AMENDMENT RECORD SHEET - LIVE APPLICATION

PLANNING AMENDMENT

H03/0602/99

RESIDENTIAL DEVELOPMENT
(10 DWELLINGS)

SITE LAYOUT
1 : 500

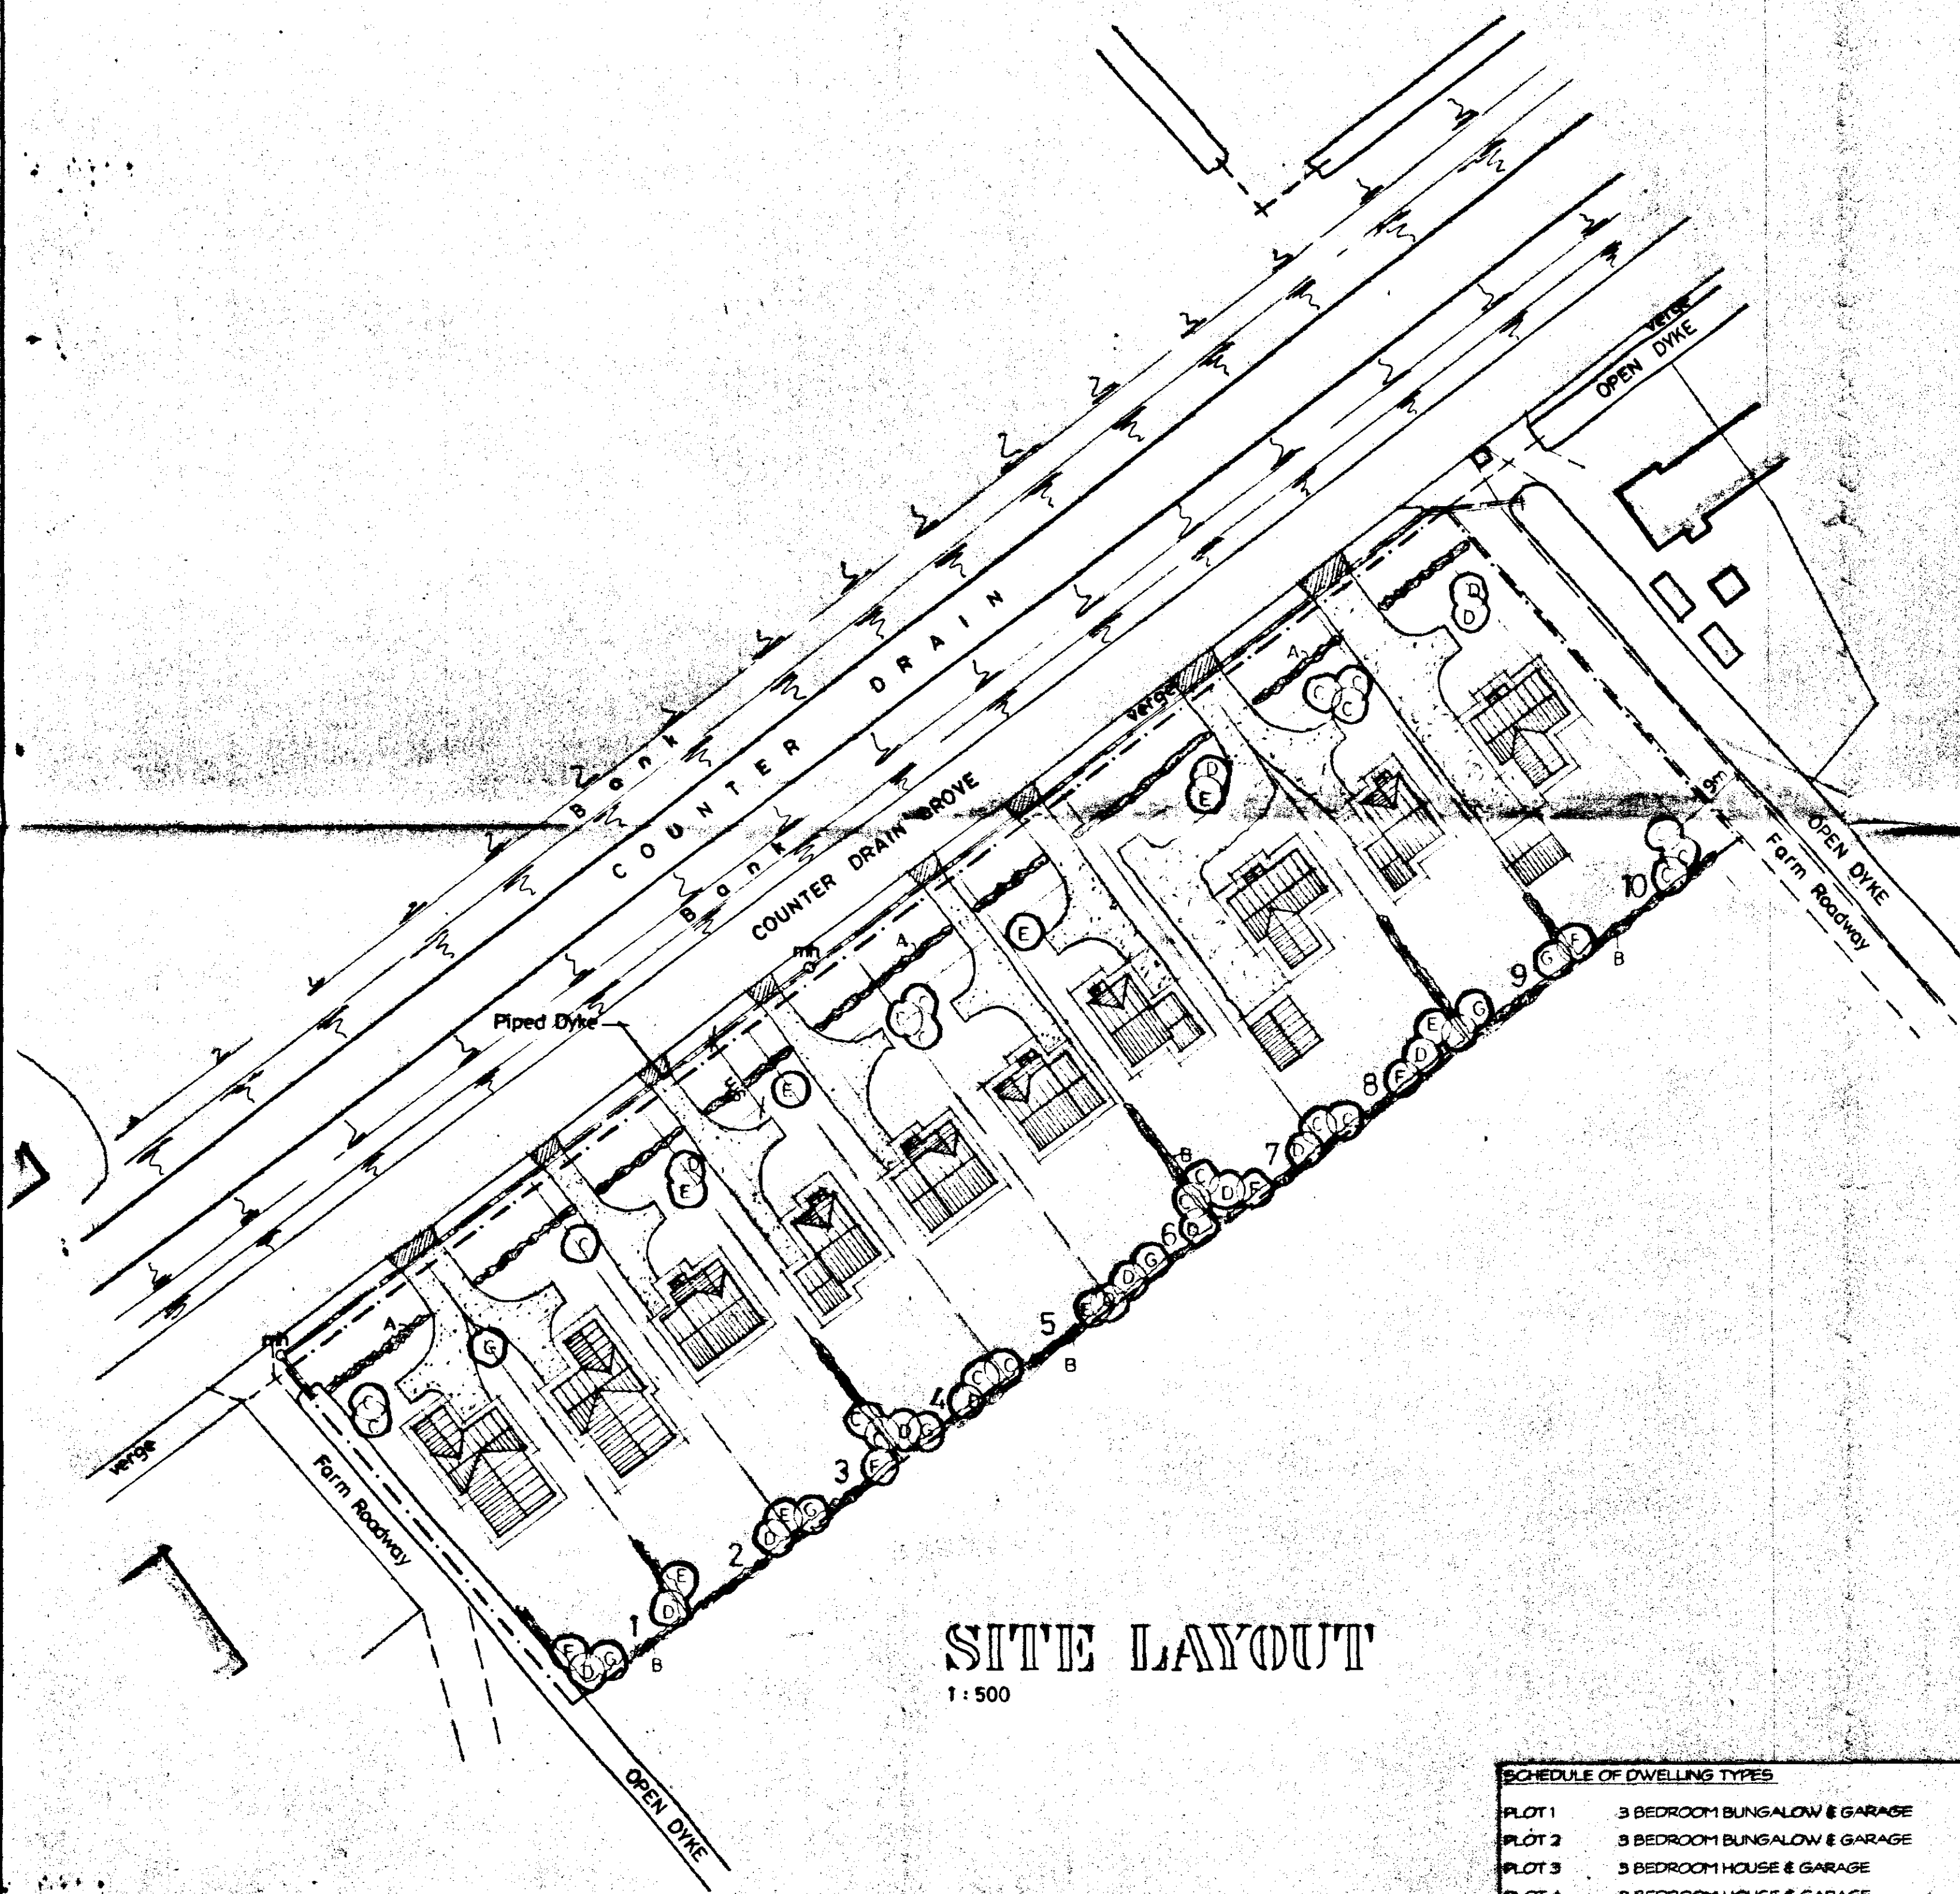
RE-POSITION GARAGE
ON PLOT 8.
